REQUEST

Current Zoning: MX-1 (mixed use district)
 Proposed Zoning: N2-A(CD) (neighborhood 2-A, conditional)

Approximately 33.95 acres located east of Bending Branch Road and west of Interstate 485, north of Albemarle Road.

The petition proposes to allow a 124-unit single family attached (townhome) residential community on vacant acreage previously approved to allow 75 single family detached homes.

**SHEET**  
**REZONING PLAN**  
**RZ.01**

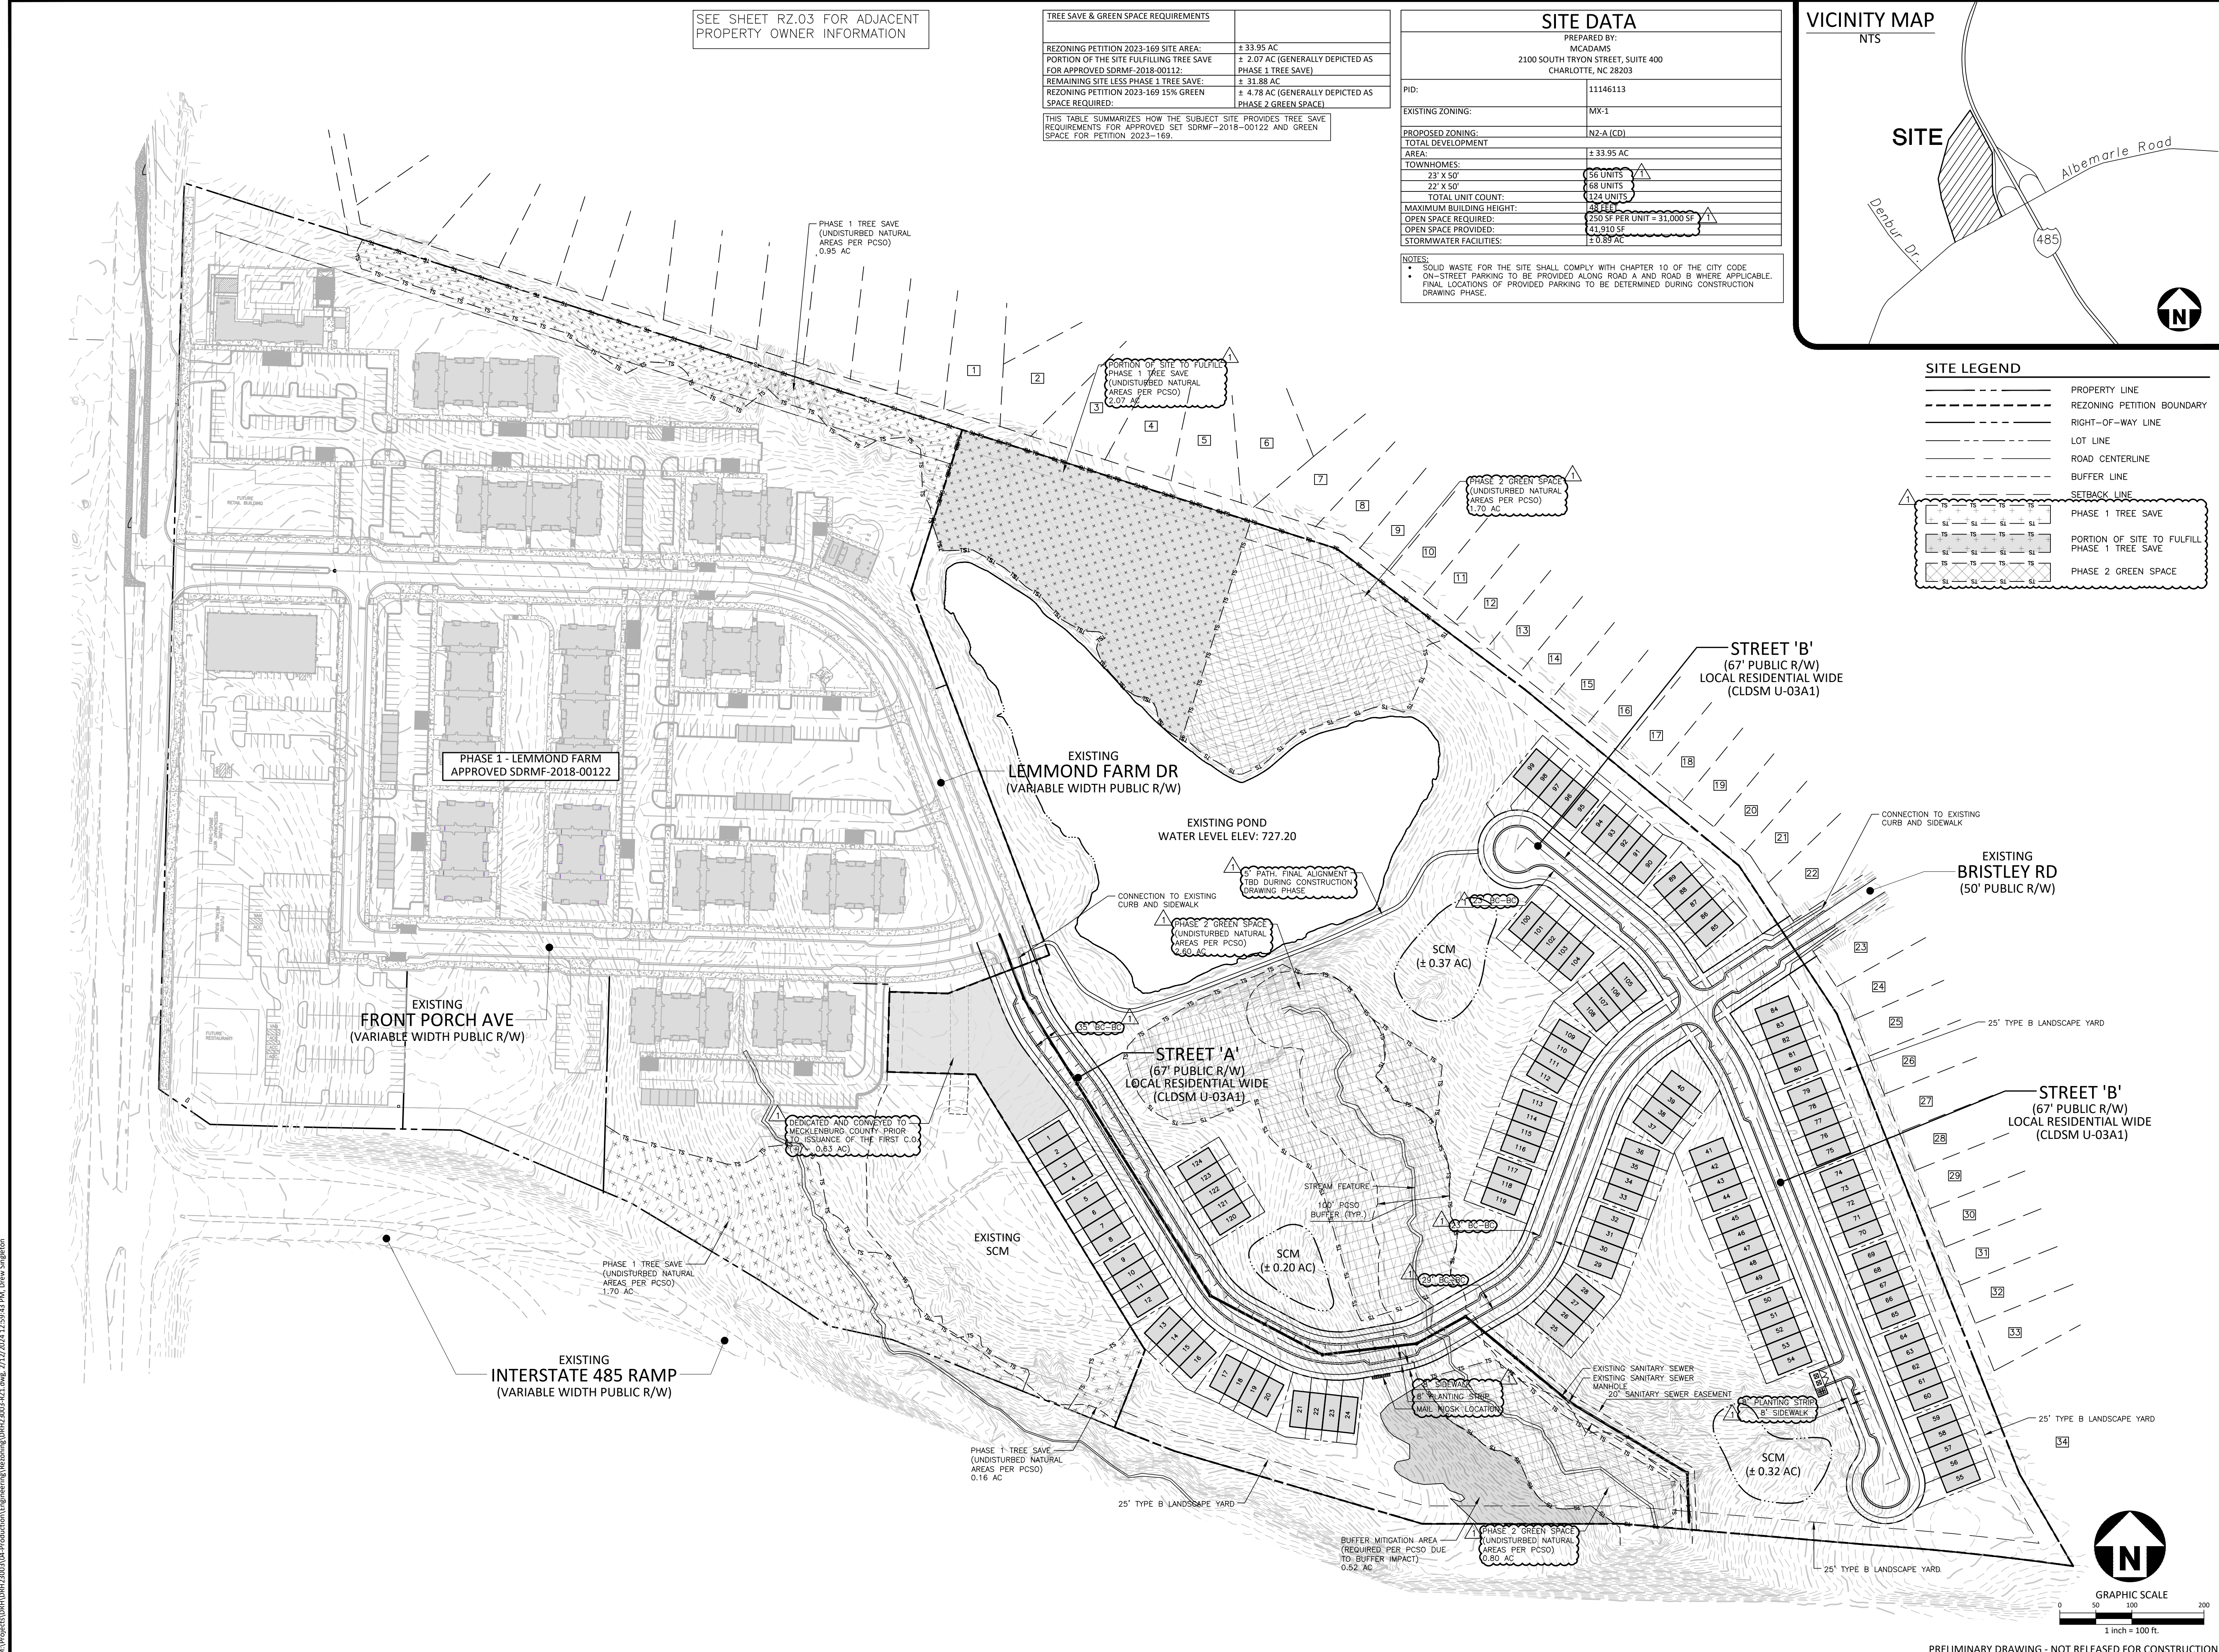
3. Please confirm with Zoning Administration if an administrative amendment is required as part of the process. **Rescinded**
4. Label setback along Public Streets A and B.
5. Label zoning of abutting parcels, including next door NS zoning.
6. Note 1.d. limits the total number of buildings to 28, but 26 buildings are shown. Please revise so the graphic depiction of the plan matches the notes.
7. Please modify Note 4.b. to refer to “landscape yard”.

8. Tree save does not appear to meet the referenced site plan.
9. Tree save has not yet been established. Green space location has already been determined per the previous plans.

RZ.02

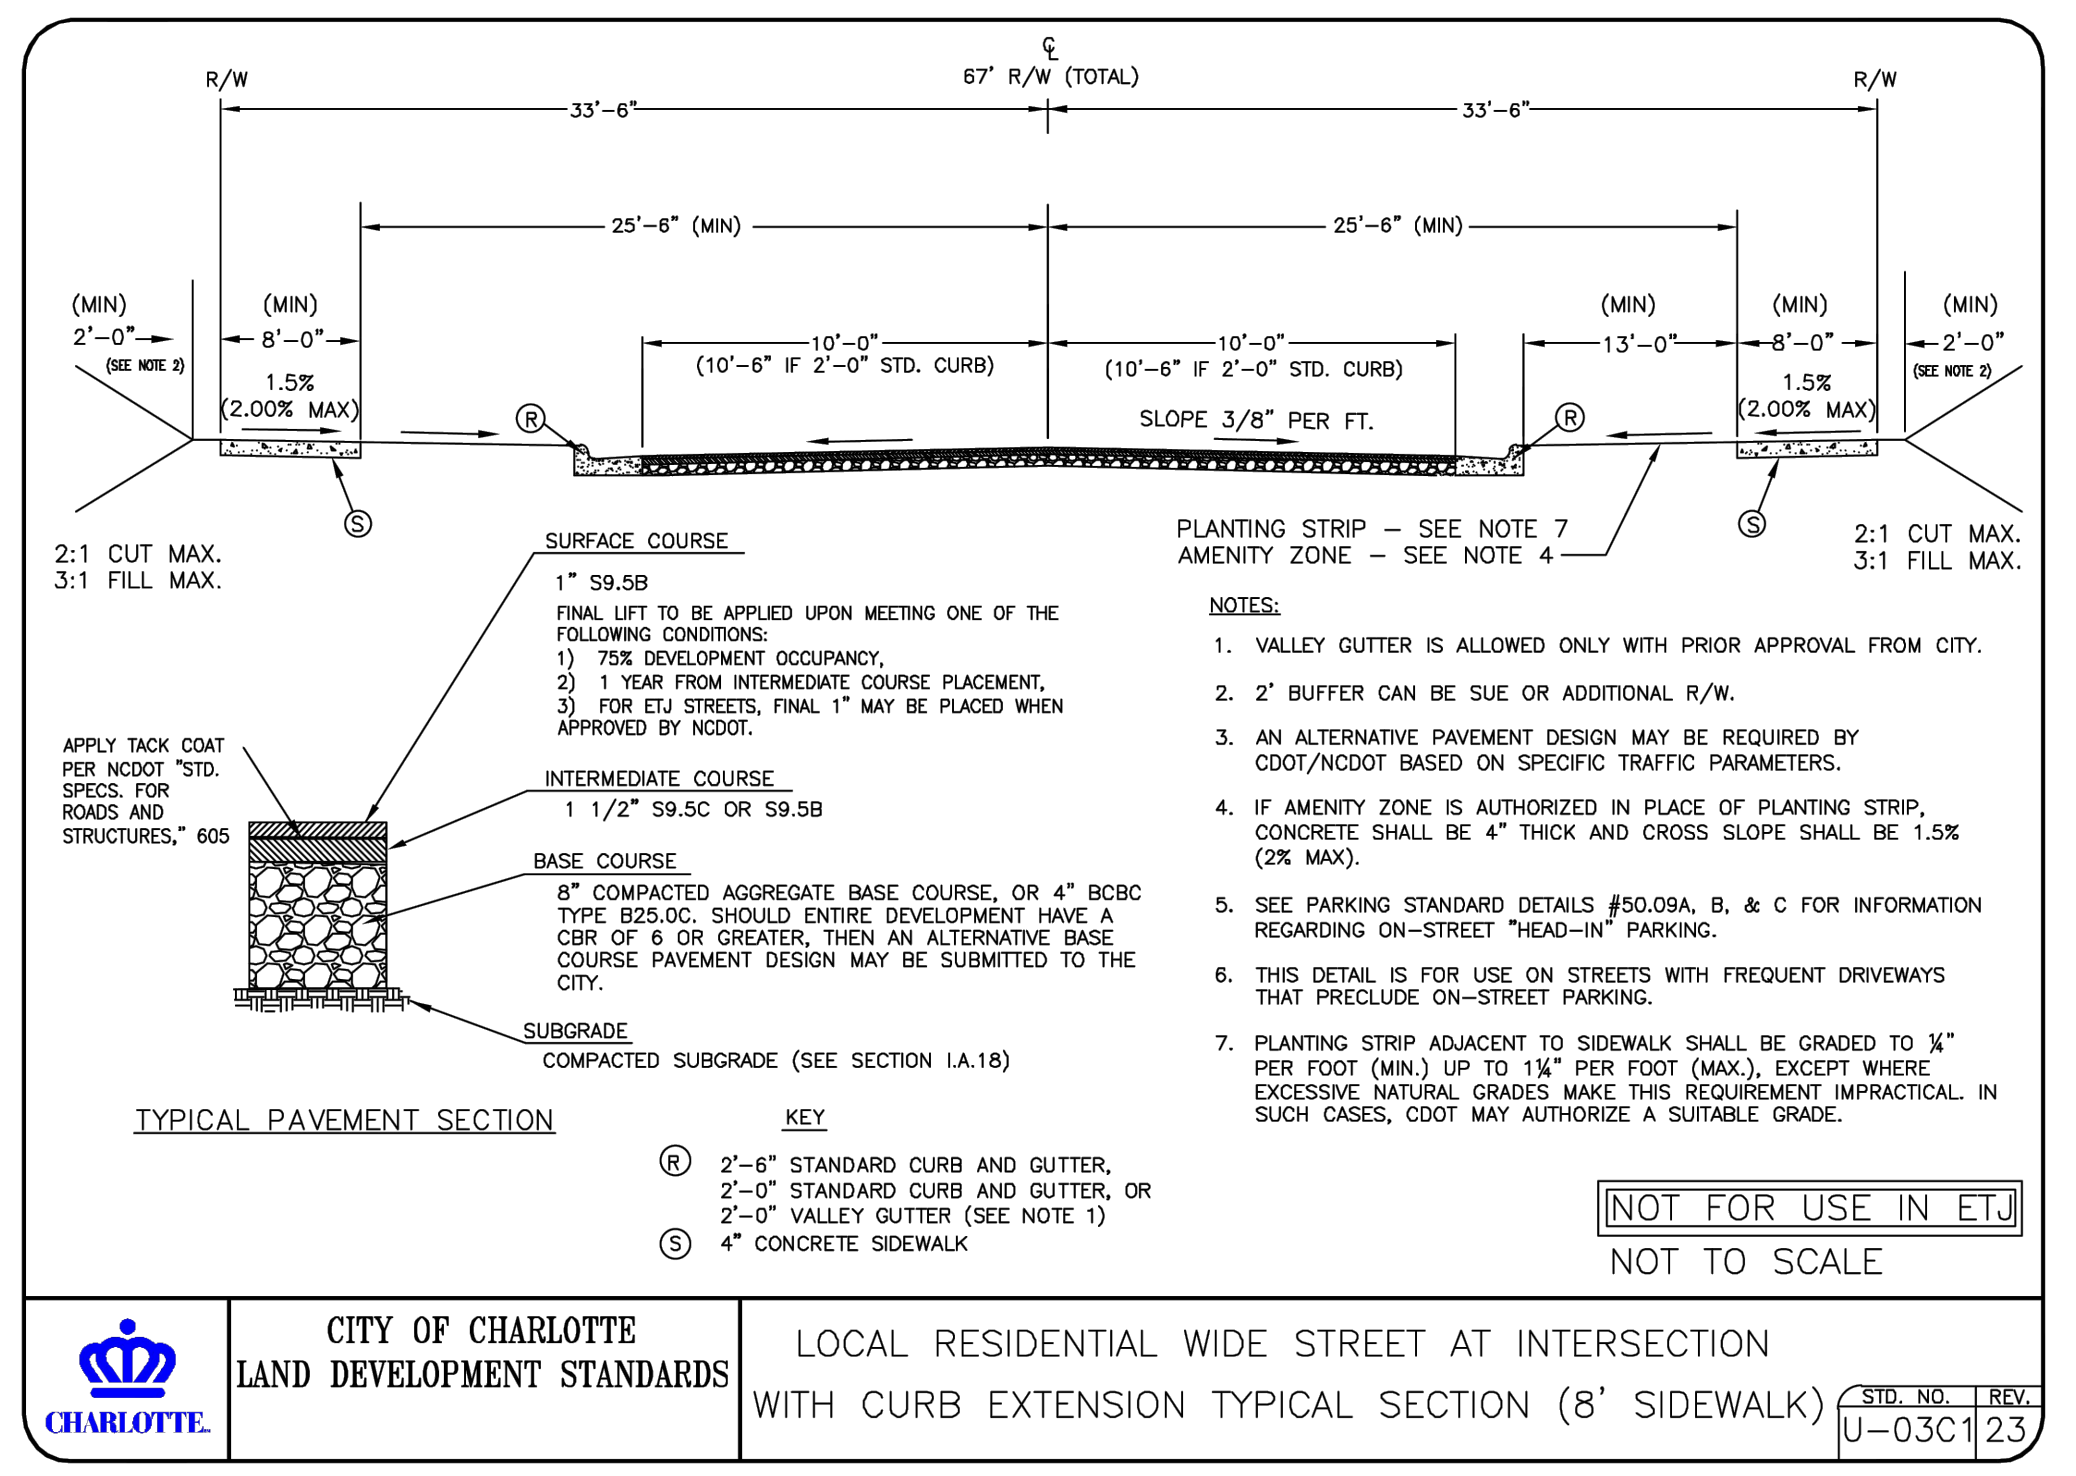
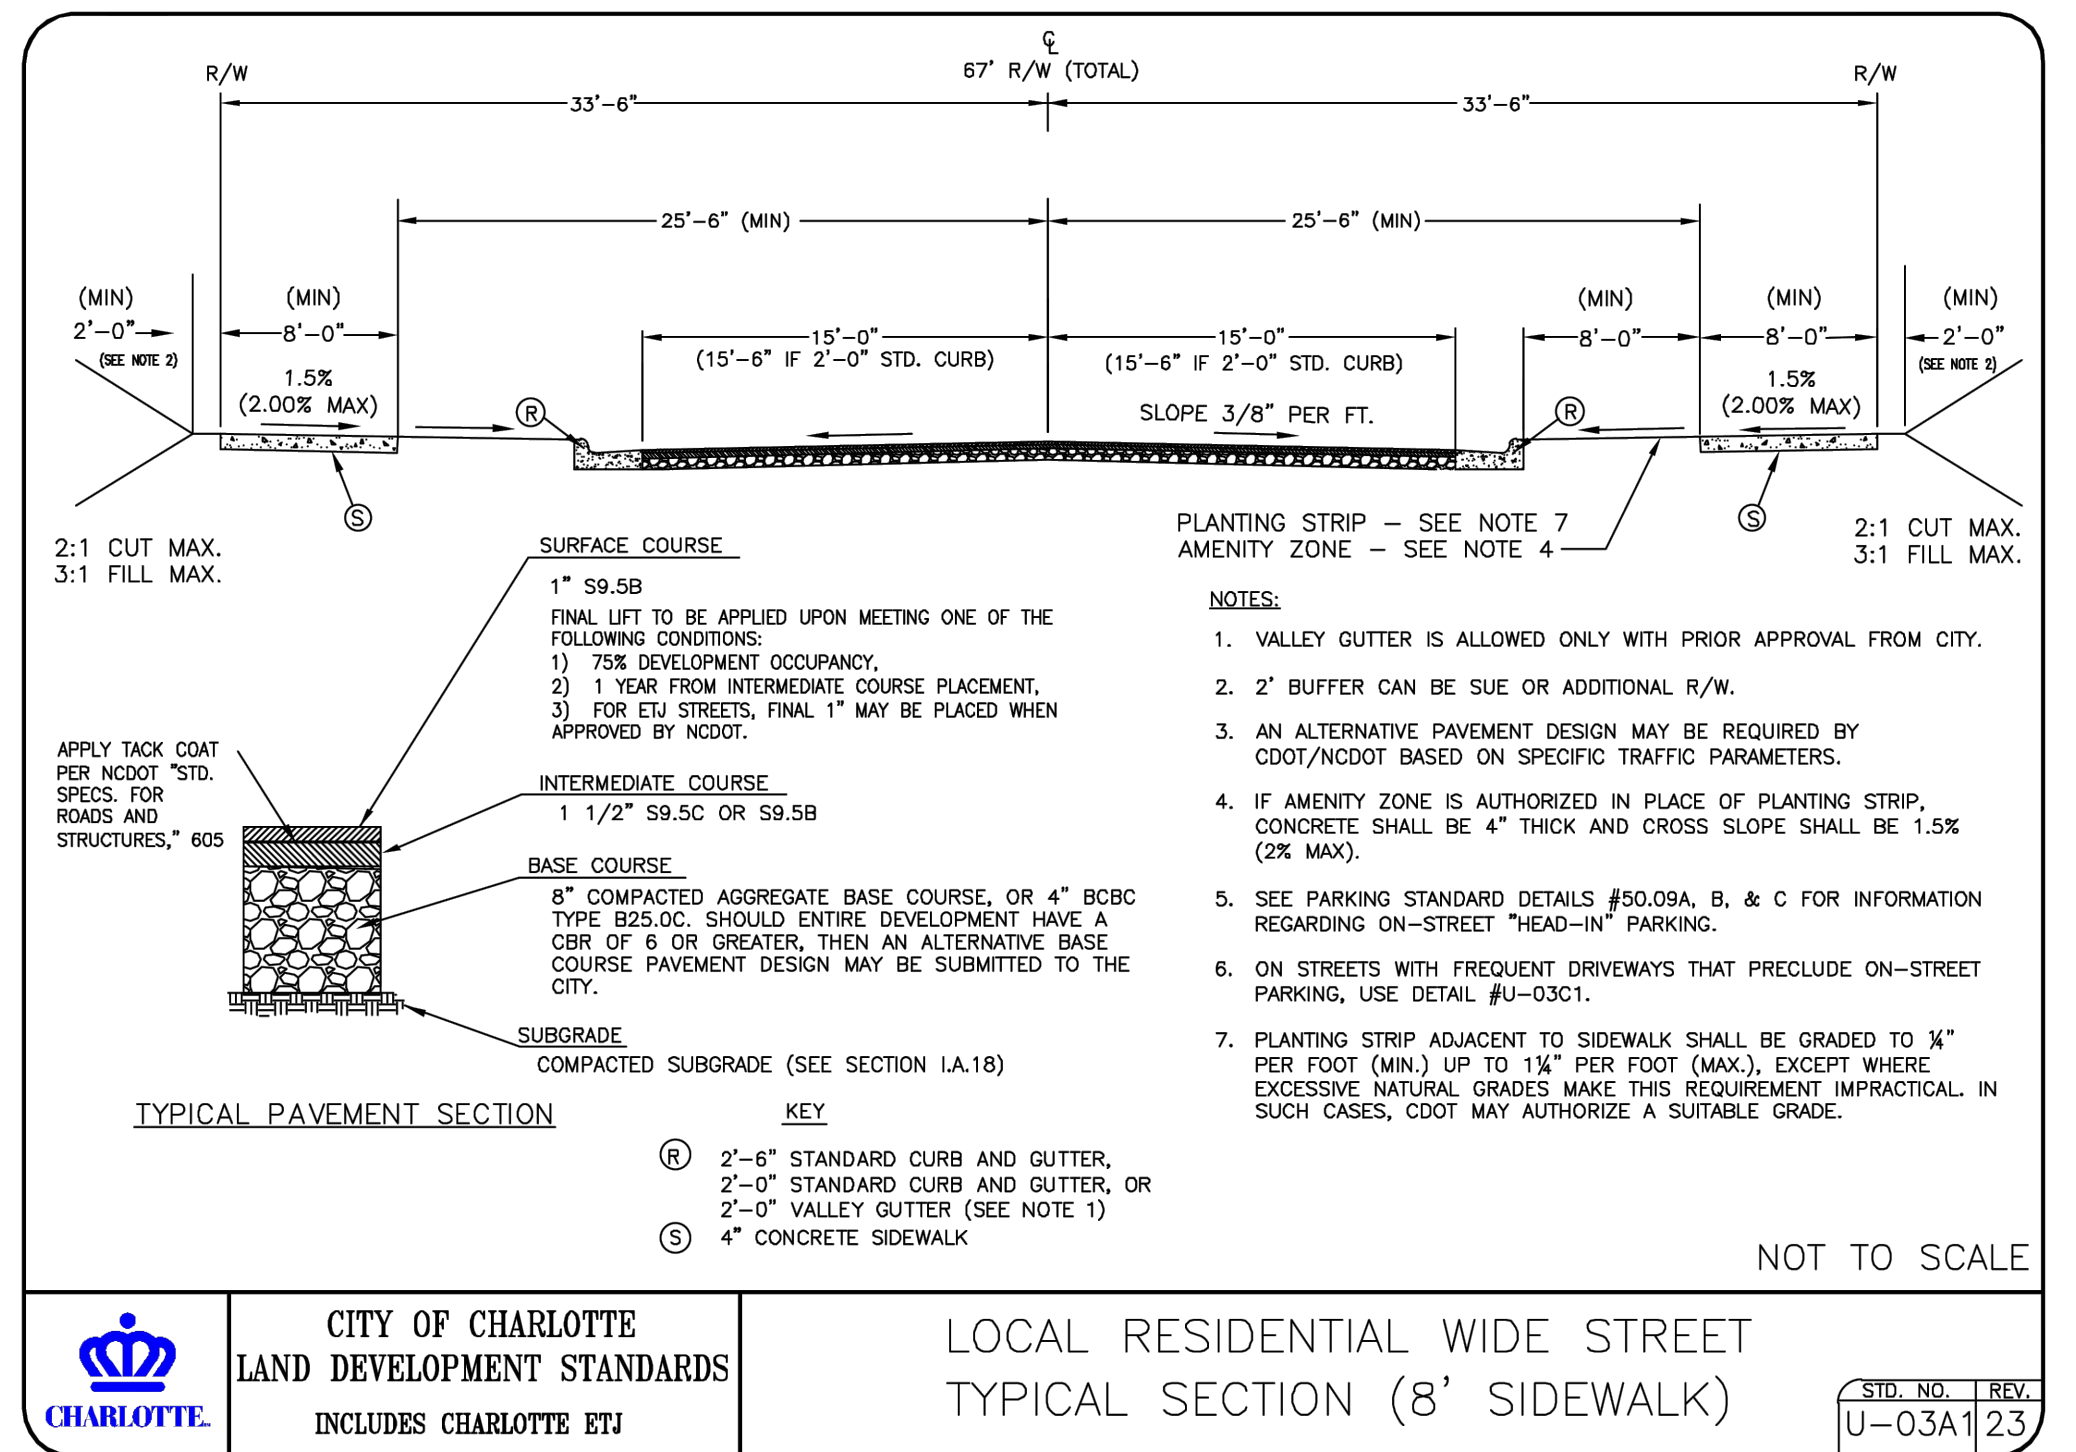
10. Please revise 6.c. to read per the standard note: Development within any SWIM/PCSO Buffer shall be coordinated with and subject to approval by Charlotte-Mecklenburg Storm Water Services and mitigated if required by City ordinance. Stream Delineation Reports are subject to review and approval by Charlotte Storm Water Services. Need to remove RZ.02 from the note.
